Lisheenkyle Group Water Scheme Co-Operative Ltd.

Submission to An Bord Pleanála - April 8th, 2026

SID application for the Cashla Peaker Plant and Above Ground Installation (AGI)

(Energy generation infrastructure – Ref: PA07.324113, deadline: 24 April 2026)

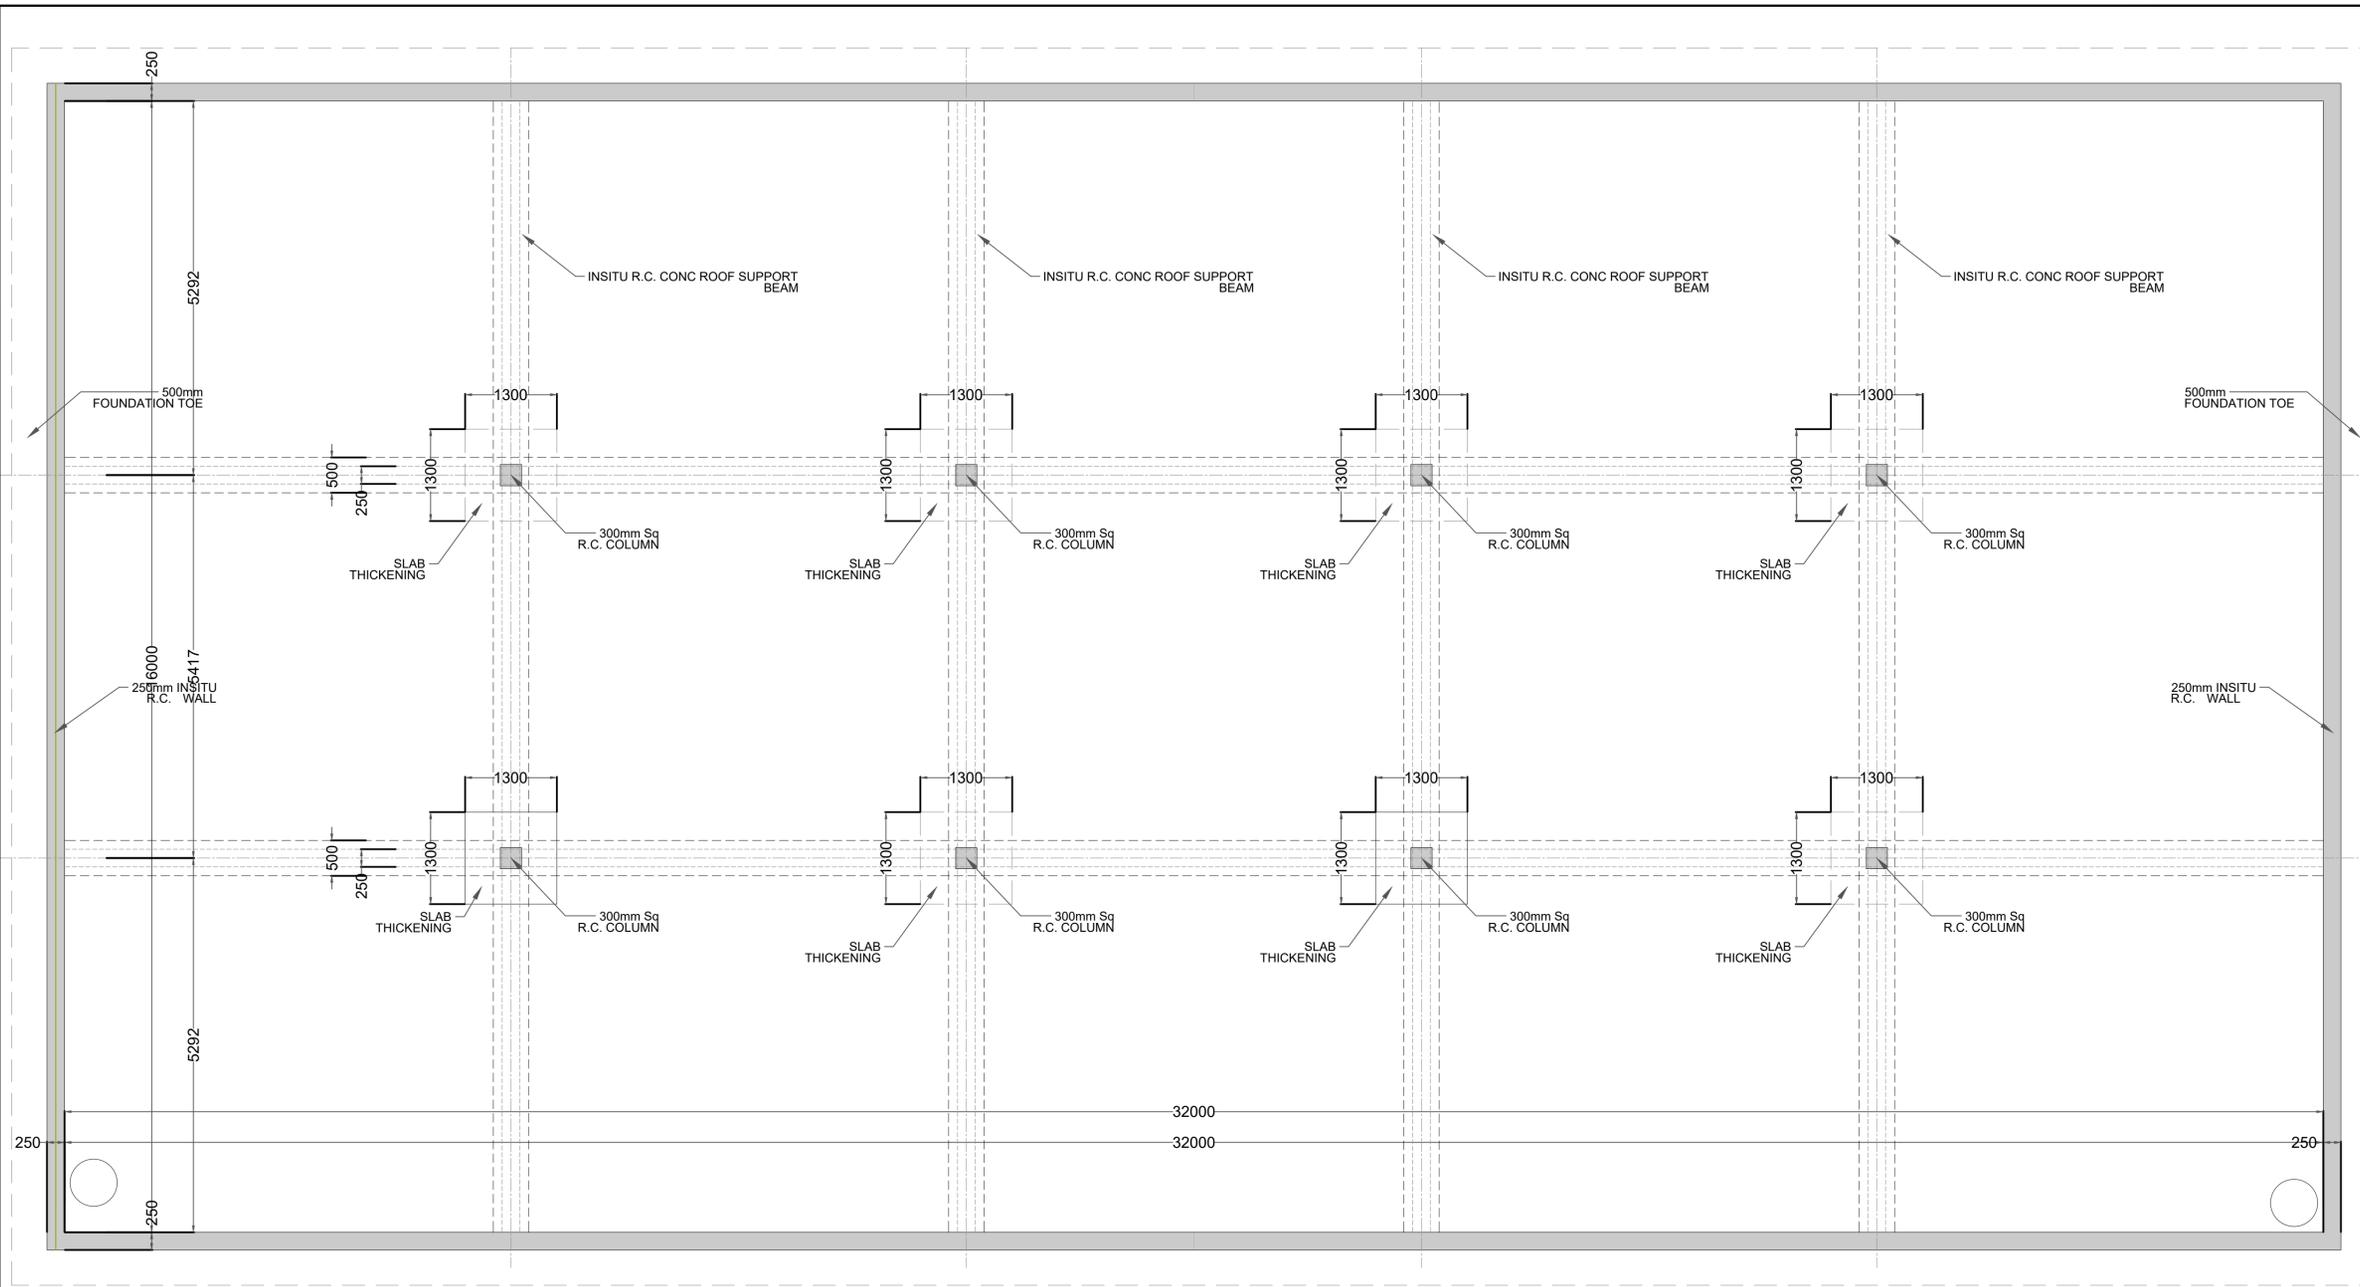
The application relies on standard mitigation measures such as bunding, underground tanks, soakaways, and pH-triggered firewater diversion systems. However, these are not demonstrated

to be fail-safe in a karst environment, where any failure could result in rapid and widespread contamination.
